Our ref: MP 08_0222
Your ref:
File: S08/01725

Director General's Requirements for Global Switch Site Redevelopment (MP 08_0222).

Application number	MP 08_0222
Project	Construction of a new 6-storey specialist data centre building with 3 basement levels
Location	273 Pyrmont Road, Ultimo
Proponent	Global Switch Property (Australia) Pty Ltd
Date issued	10/2/09
Expiry date	If the Environmental Assessment (EA) is not exhibited within 2 years after this date, the applicant must consult further with the Director-General in relation to the preparation of the environmental assessment.
Key issues	<p>The EA must address the following key issues:</p> <p>1. Relevant Environmental Planning Instruments (EPIs) policies and Guidelines to be Addressed:</p> <ul style="list-style-type: none"> • State Environmental Planning Policy (Major Projects) 2005 • State Environmental Planning Policy (Infrastructure) 2007 • State Environmental Planning Policy No. 55 – Remediation of Contaminated Sites • Sydney Regional Environmental Plan (Sydney Harbour Catchment) 2005 • Sydney Harbour Foreshores & Waterways Area DCP • Darling Harbour Development Plan No.1 • Ultimo Pyrmont Section 94 Contributions Plan, and • T

drwg no.
 arskDG01

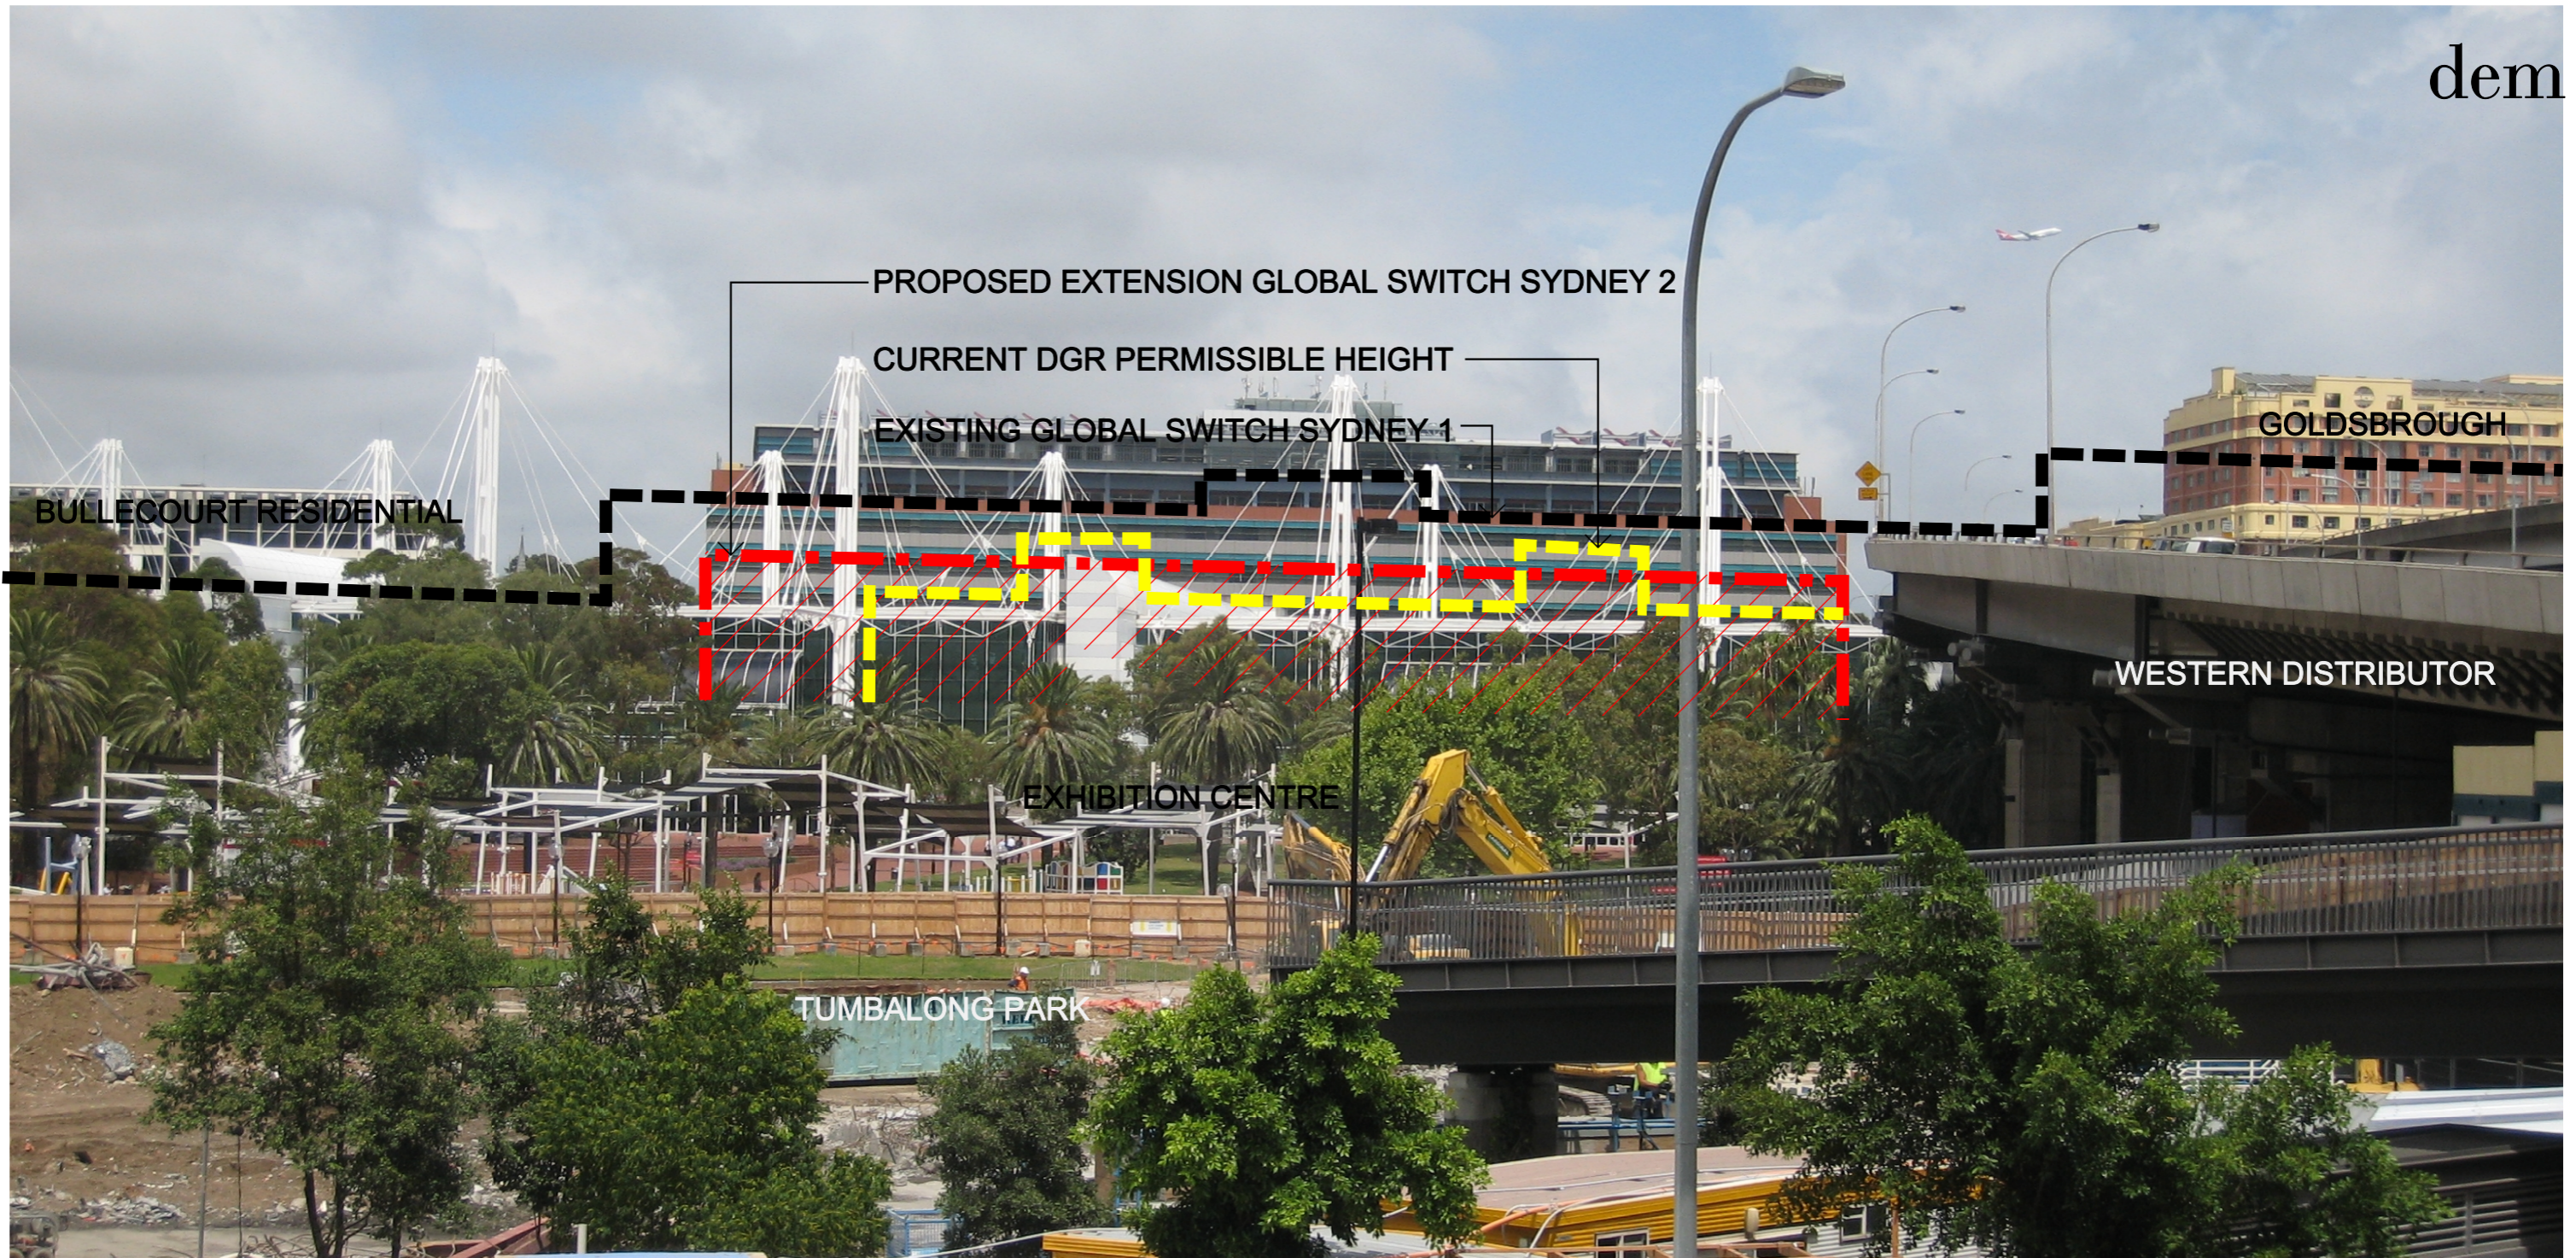
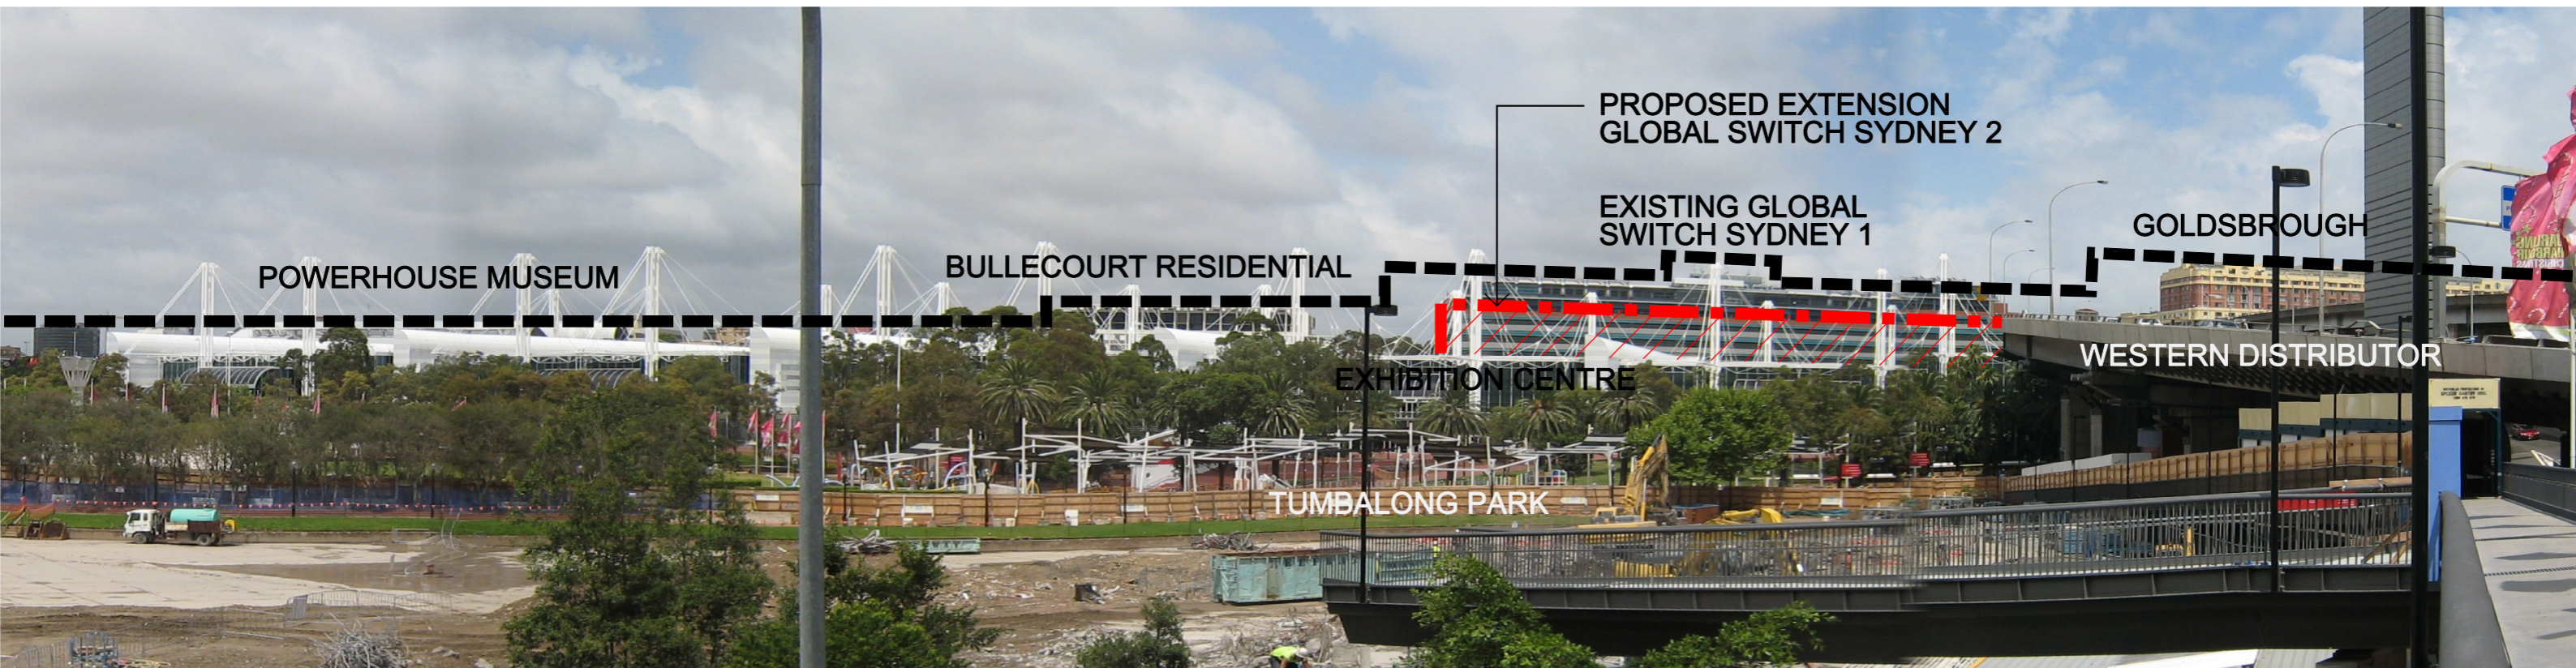
The Department also maintains concern about the height and massing of the building, and its relationship to Goldsbrough Mort, Bullecourt and the existing Global Switch developments. The proposed height of the building exceeds the prescribed height under the Master Plan. The former design for the building achieved greater design articulation, incorporating parapets set back from Pyrmont Street, and an overall lower profile. In accepting that a height greater than that of the current Master Plan may be justified, it was previously determined that any new height should not exceed the original parapet height of the GPO (Global Switch 1) building. It is appreciated that the upper levels would comprise plant areas, but these floors would still contribute to the overall mass of the building and its visual impact.
